Kitchen Plumbing Clarifications

TO:	Miranda Jones (WBRC Architects and Engineers) 44 Central Street Bangor, Maine 04401	FROM:	Jason Goggin (Consigli Construction Co., Inc.) 15 Franklin Street Portland, Maine 04101
DATE INITIATED:	07/22/ 2016	STATUS:	Open
LOCATION:		DUE DATE:	07/26/2016
COST CODE:		REFERENCE:	
COST IMPACT:	TBD	SCHEDULE IMPACT:	TBD
DRAWING NUMBER:	PL102, PL401, FS001, PL101	SPEC SECTION:	
RECEIVED FROM:	Mike Lowe (Damon Refrigeration Co, Inc.)

Responses per numbered items in RFI #23

H1 KITCHEN 102 ENLARGED PLUMBING PLAN ①

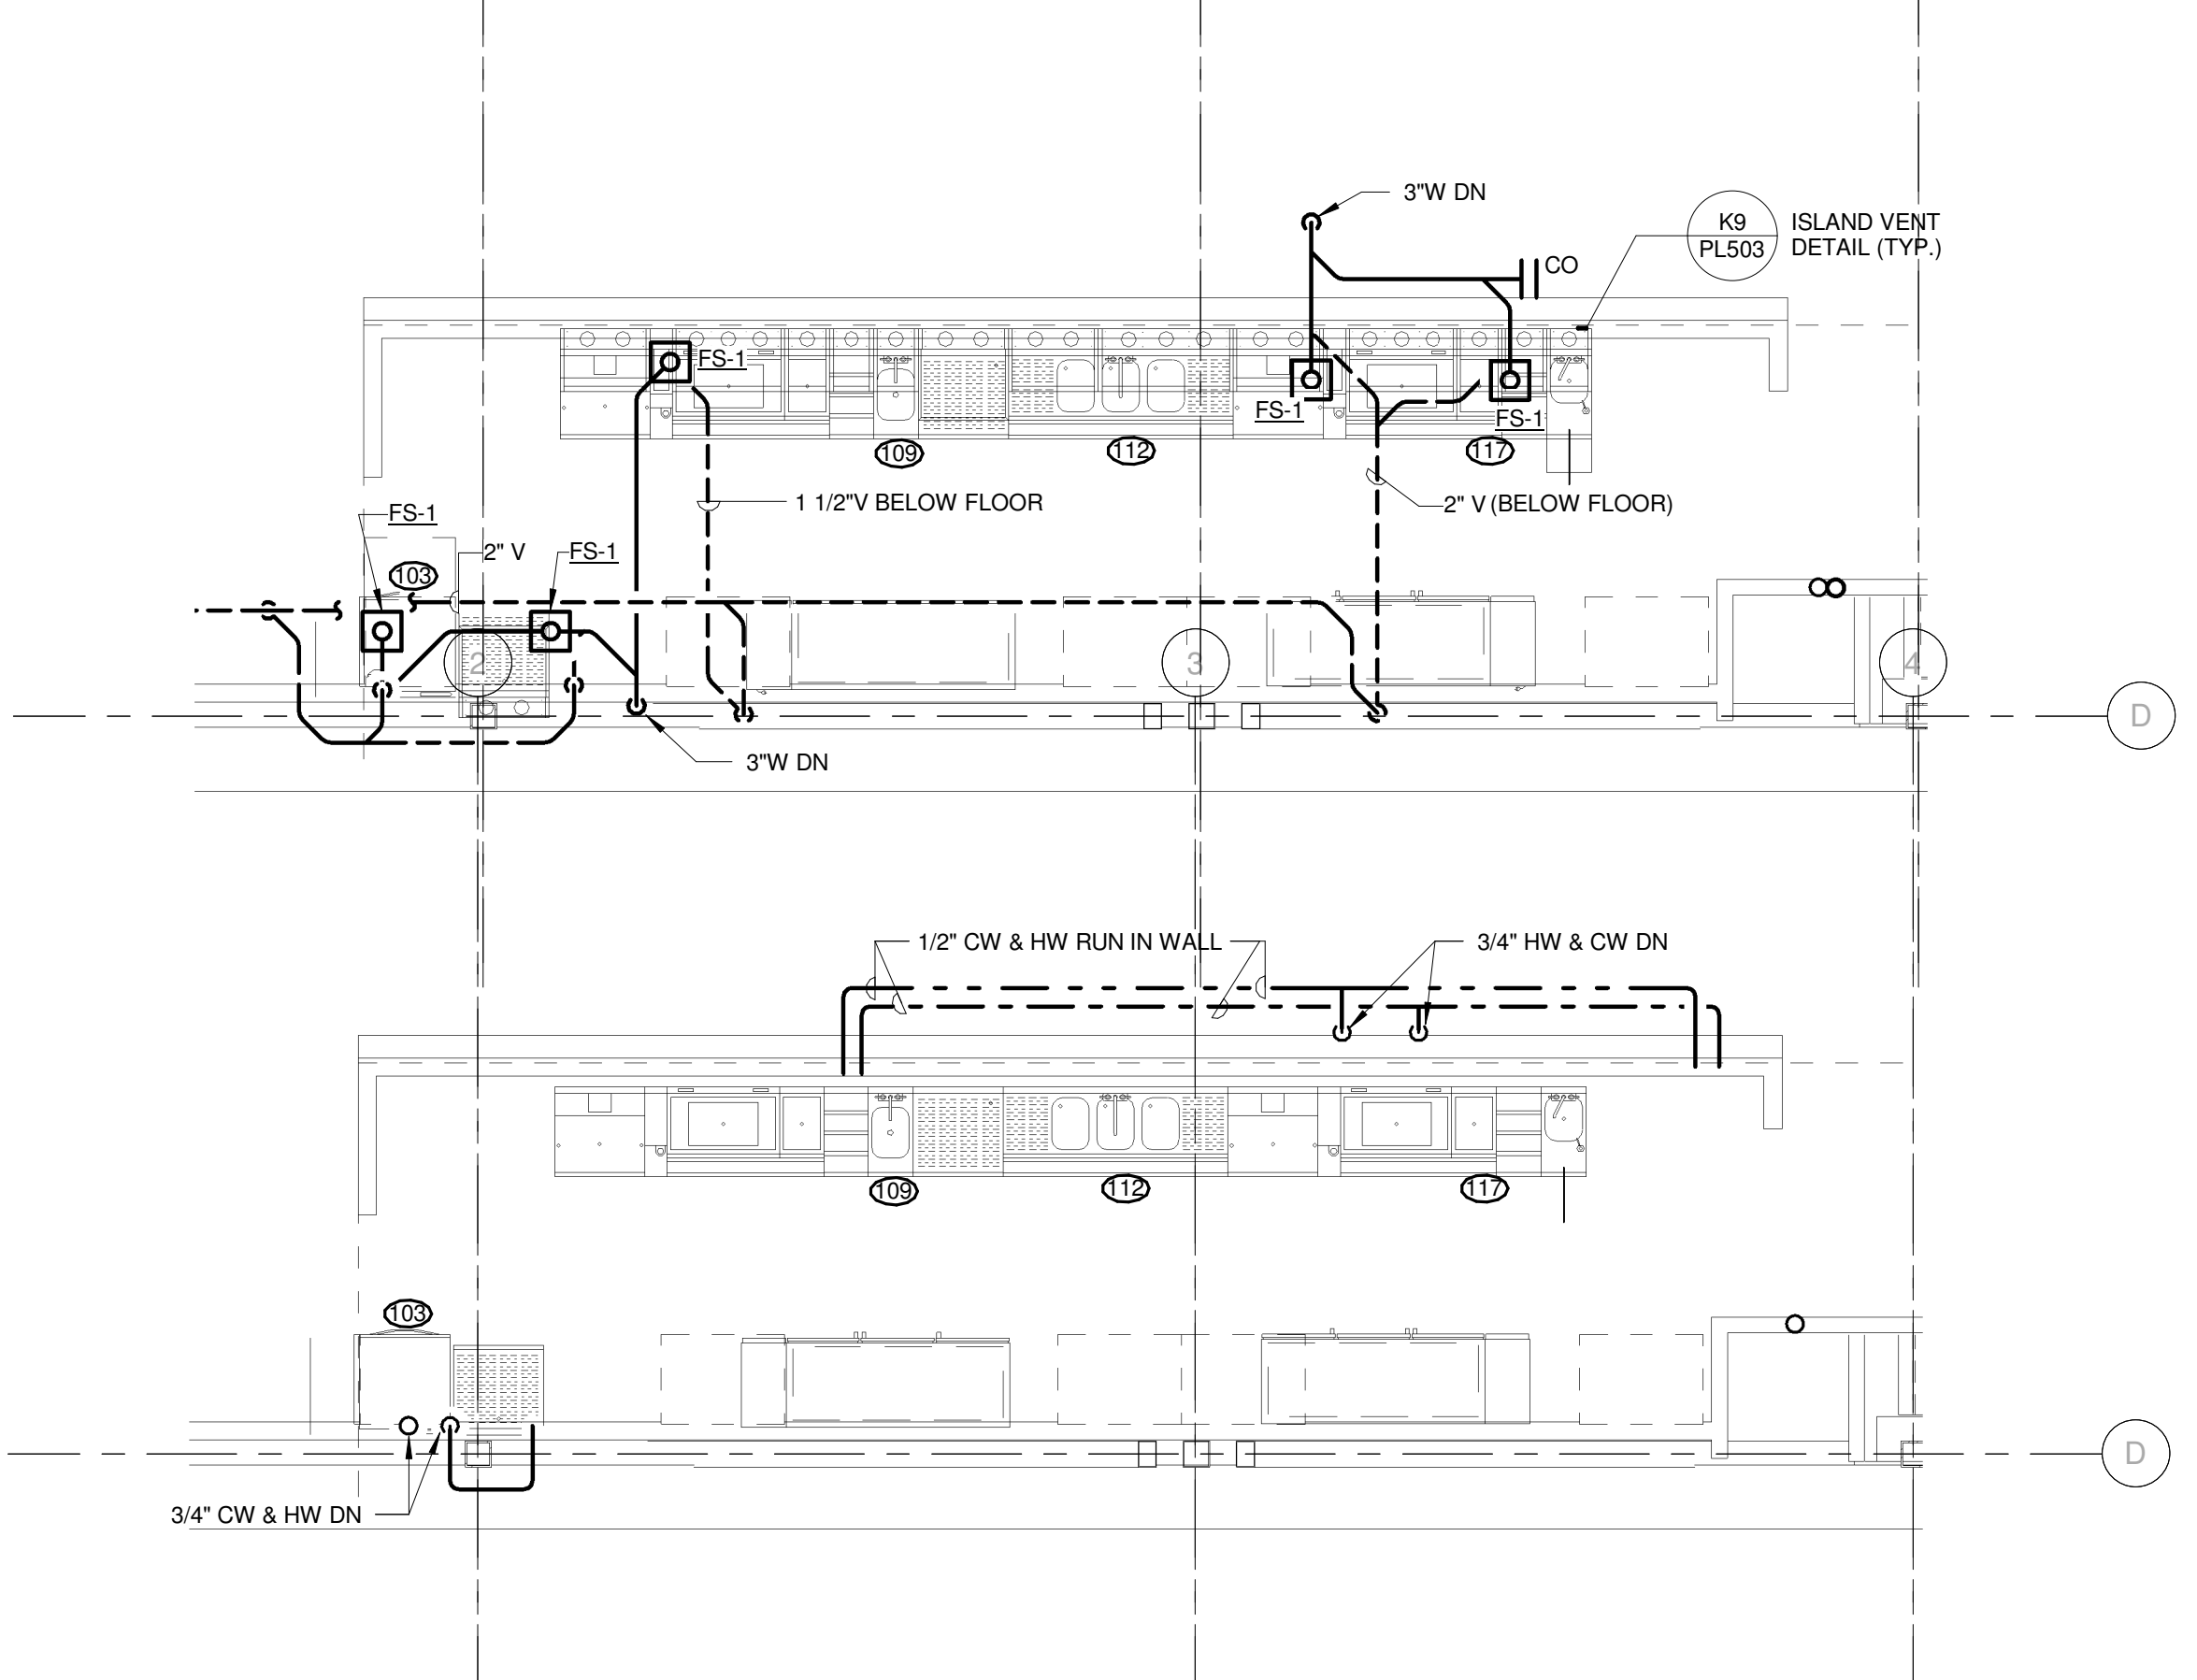
7. Per detail H1 on PL401 a new 10 outlet electronic trap primer is to serve the kitchen area floor drains. Note that the plumbing code does not require trap primers for all floor drains, only required for floor drains infrequently used. Where this is an active kitchen with floors cleaned daily, these drains should be receiving some sort of daily use. We propose removing these trap primers for the kitchen floor drains where they are frequently used to save time and money. There would be a credit associated with the removal of this scope of work. Please advise how we are to proceed.

7. Provide trap primers as indicated. Omitting trap primers in the kitchen and any proposed cost and time savings may be considered only if Contractor obtains approval in writing from the local plumbing inspector.

**Kitchen Plan**  
Scale: 1/4"=1'-0"

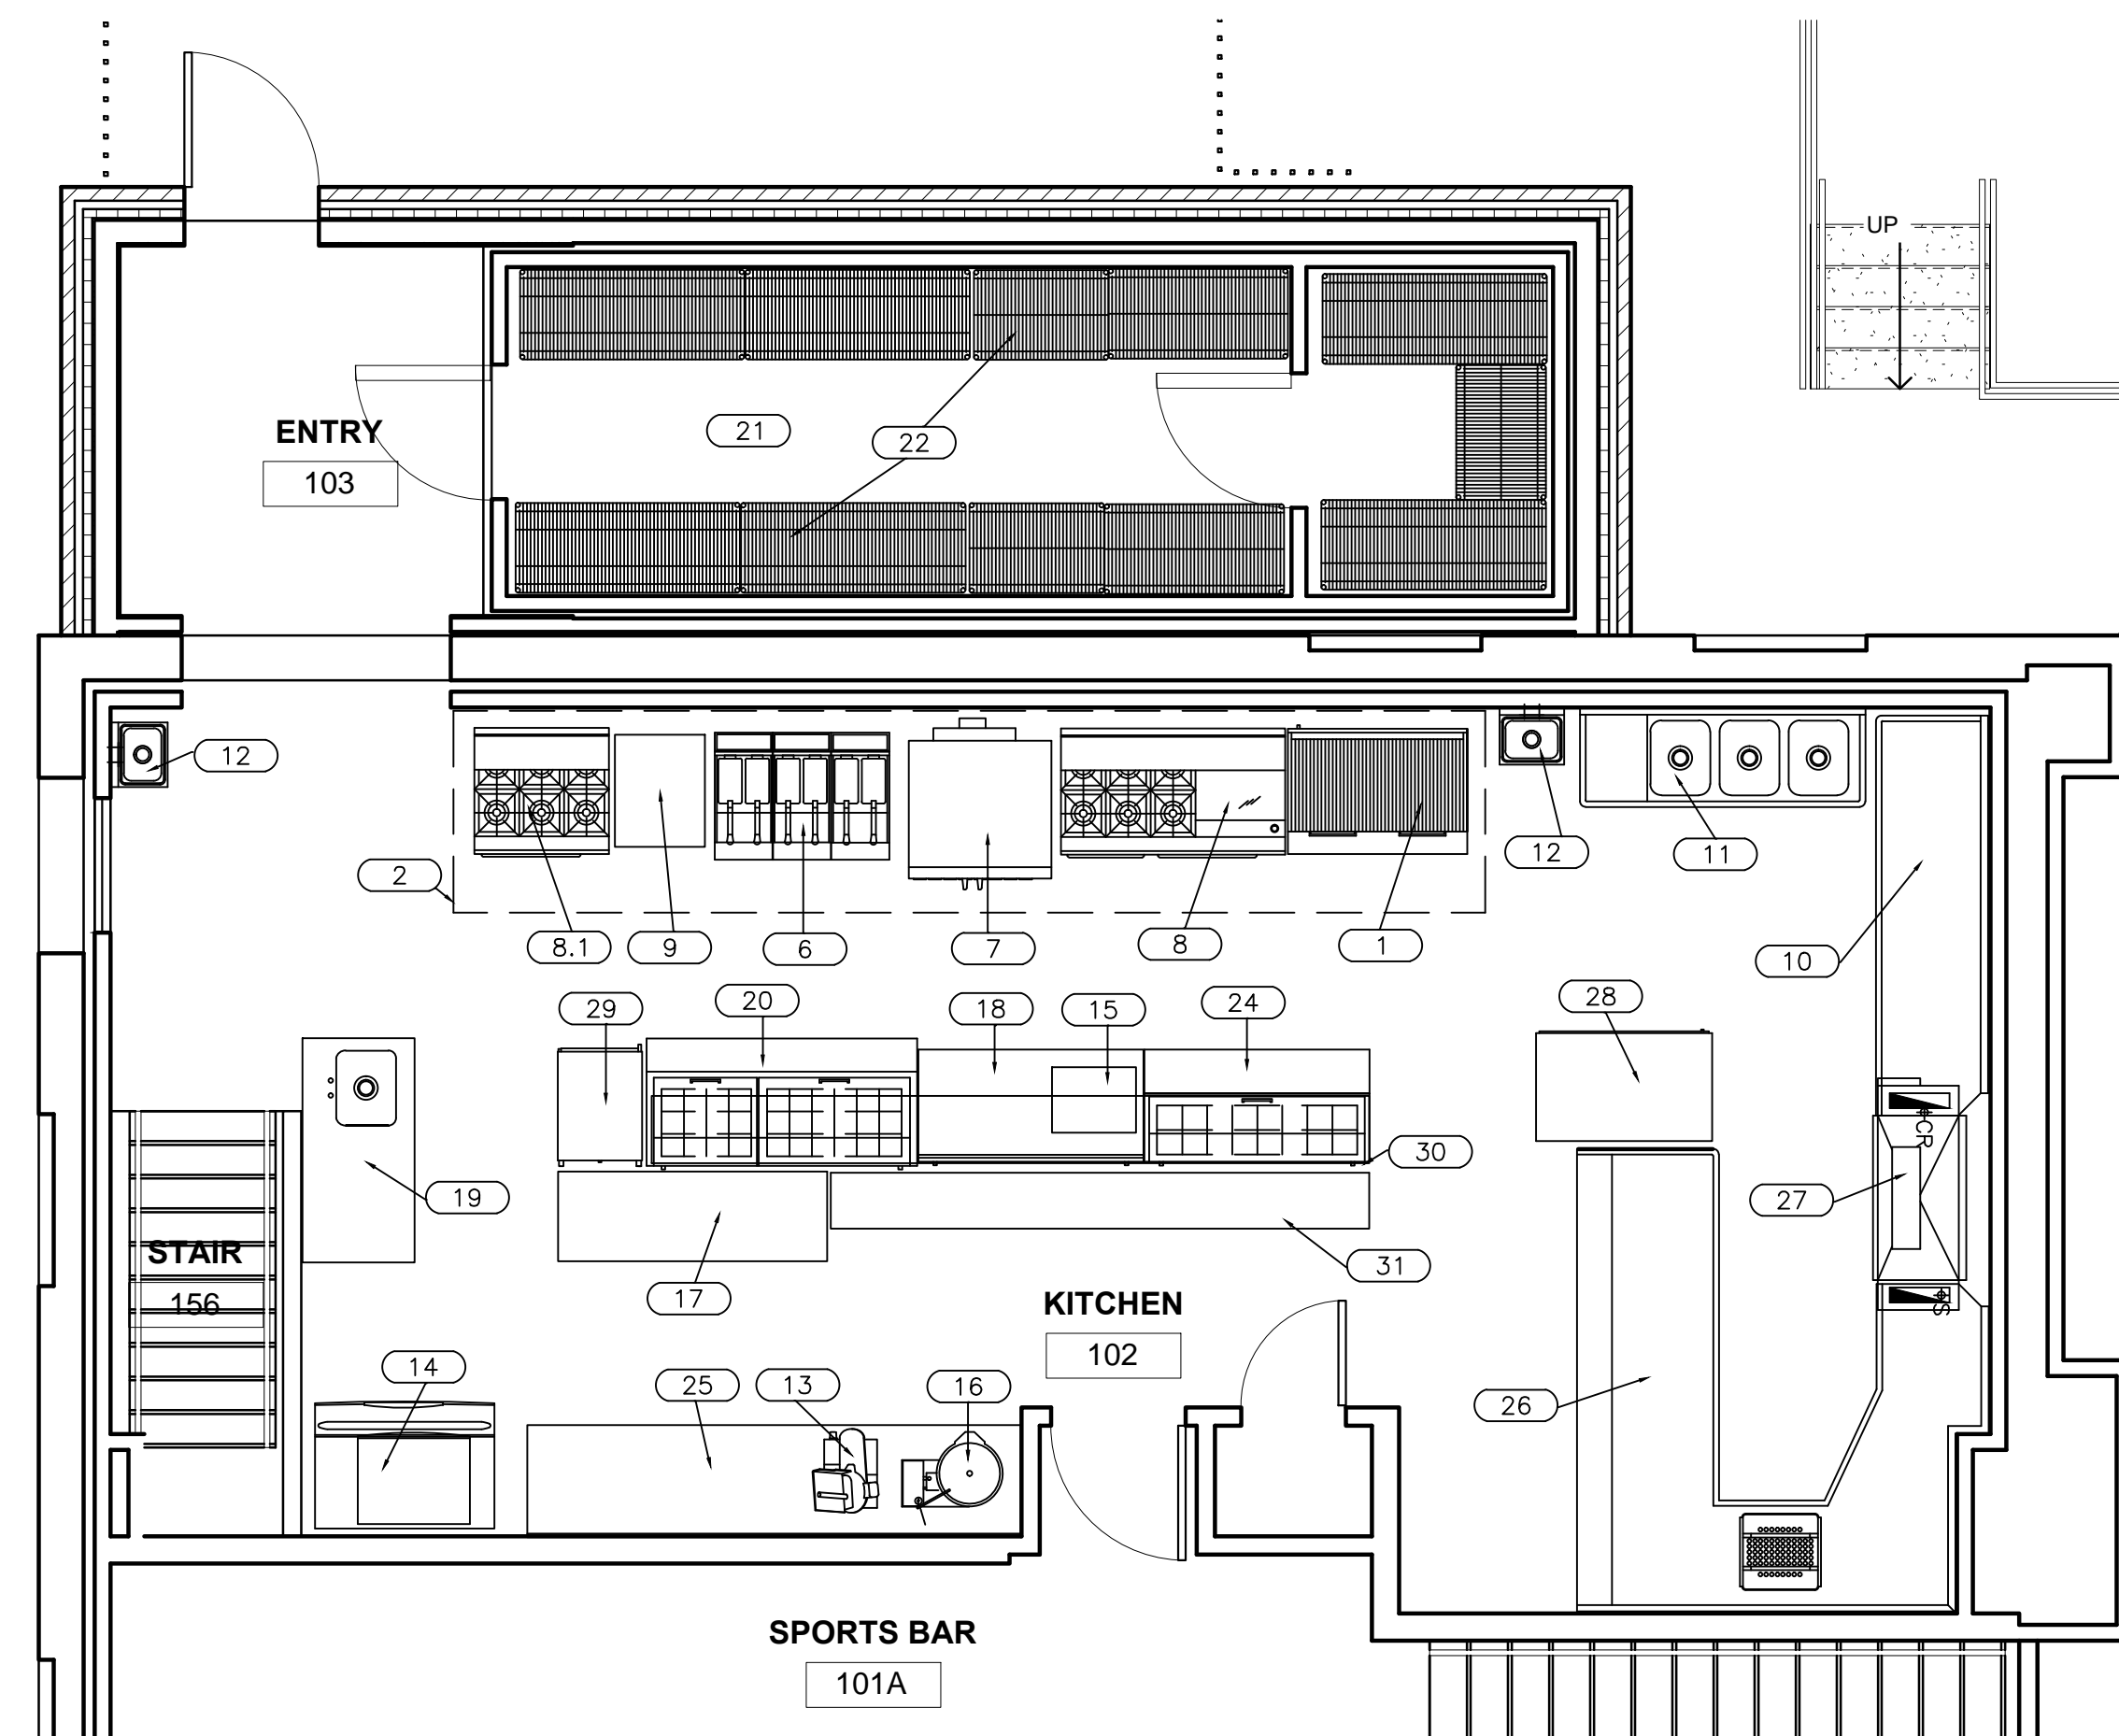
3. Per PL02 there is an existing floor drain FD-E to serve work table #19 which is currently located 2'-9" off the existing wall to remain. Per the kitchen equipment drawing FS001 this floor drain is to be located at 1'6" off the wall with indirect drains from the table to it. Left in the existing location as shown appears to be a potential tripping hazard. Note that relocating this drain would have additional cost. Please confirm the required location of this drain and how to proceed.

2. Intent is to conceal vent piping. Coordinate with RFI #11 response regarding kitchen walls.
3. Remove FD-E. Provide a new floor sink type FS-1 in location as indicated in the referenced kitchen equipment drawing. Coordinate with RFI #16 response regarding the kitchen floor.
